CITY OF ALBUQUERQUE

May 15, 2024

**RE: Quik Trip Store #7001
521 Unser Blvd NW
Conceptual Grading & Drainage Plans
Engineer's Stamp Date: No Date
Hydrology File: K10D071**

SHEET TITLE:
GRADING PLAN NORTH

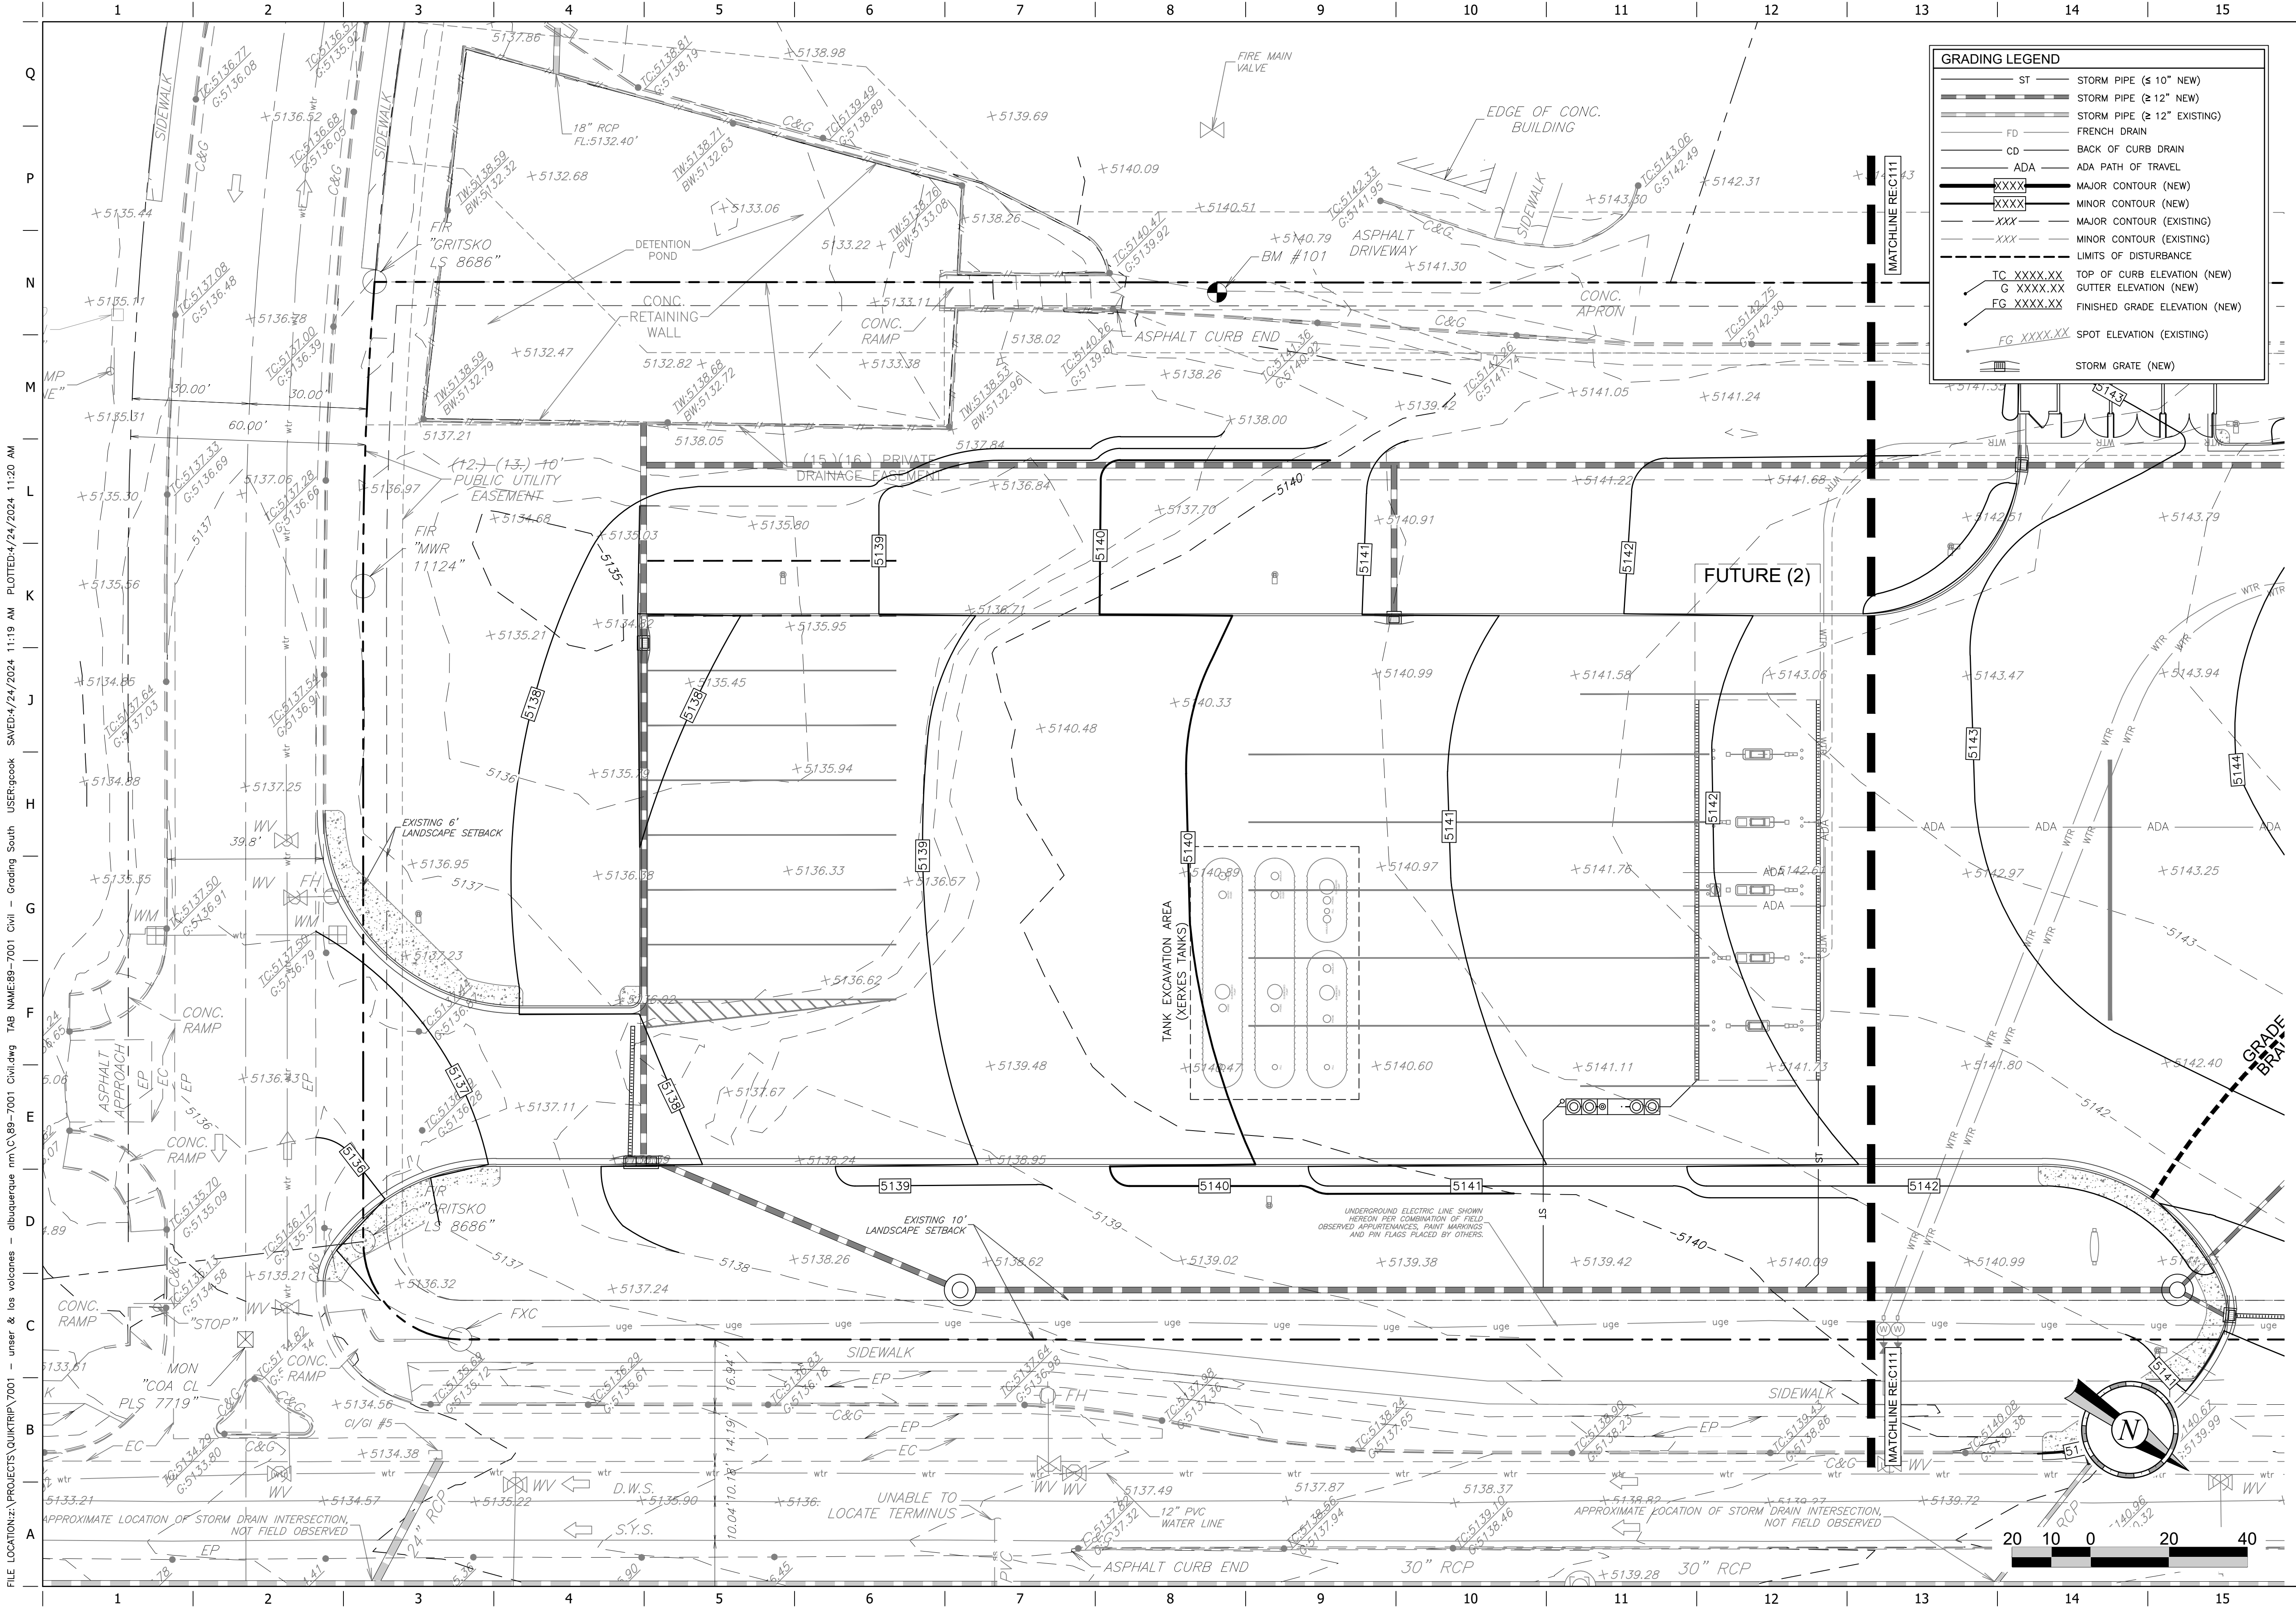
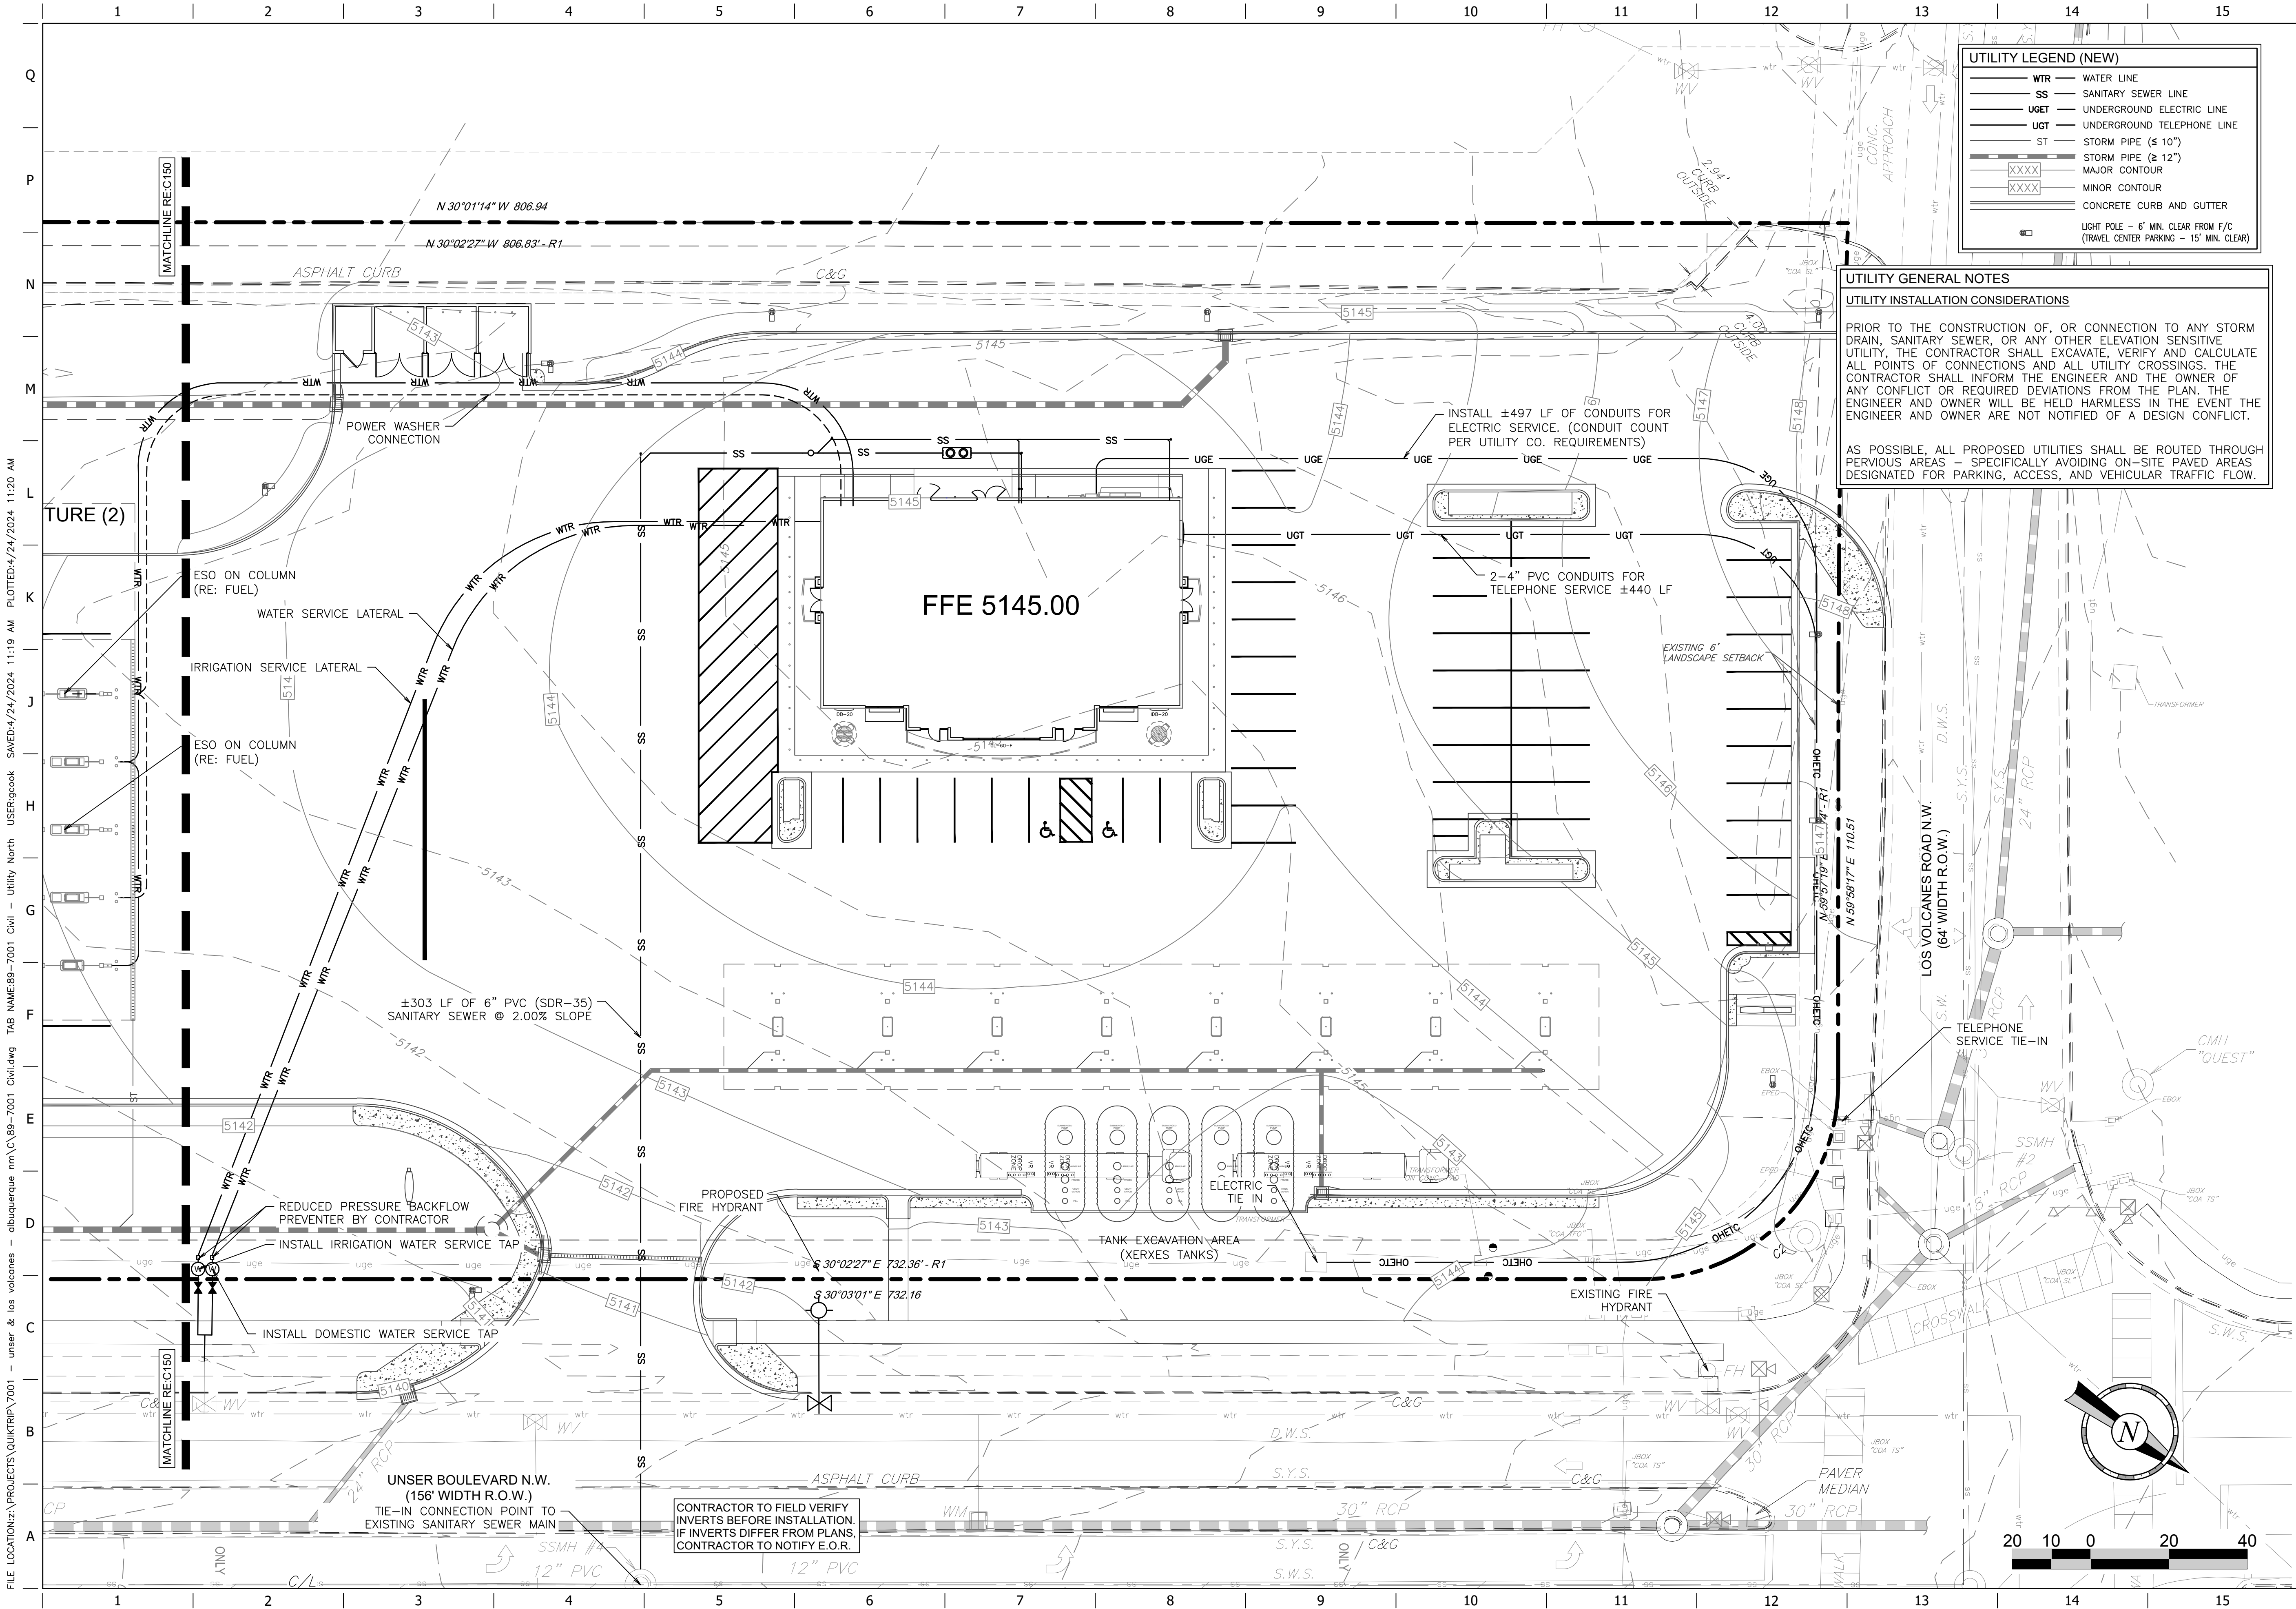
1. Most of this information was provided on the Cover Sheet. However, per the DPM the following must be on the Grading Plan. Please note the Grading Plan must be a stand-alone construction document.

- a. Please provide a Vicinity Map. Typically, this is the Zone Atlas. This can be downloaded in pdf format from the City of Albuquerque's website.
 - b. Please provide the Benchmark information (location, description and elevation) for the survey contour information provided.

- c. Please provide the FIRM Map and flood plain note with effective date.
 - d. Please provide a legal Description of the property.
2. Please use the procedure for 40 acre and smaller basins as outlined in Development Process Manual (DPM) Article 6-2(a). Please provide both the existing conditions and proposed conditions for the 100 year-6 hour storm event.

5. Please number the ponds and include a label on each with the SWQV and elevation, the 100-year volume and elevation, the peak 100-year inflow and outflow, the spillway crest elevation, the spillway flow depth, and the dam top elevation.

7. Please include the proposed pipe sizes on the Conceptual Grading & Drainage Plans.
8. There is an existing inlet at the driveway location. The entrance needs to be shifted over about 15 feet to ensure that the back of curb radius is tangent at the inlet's transition section.
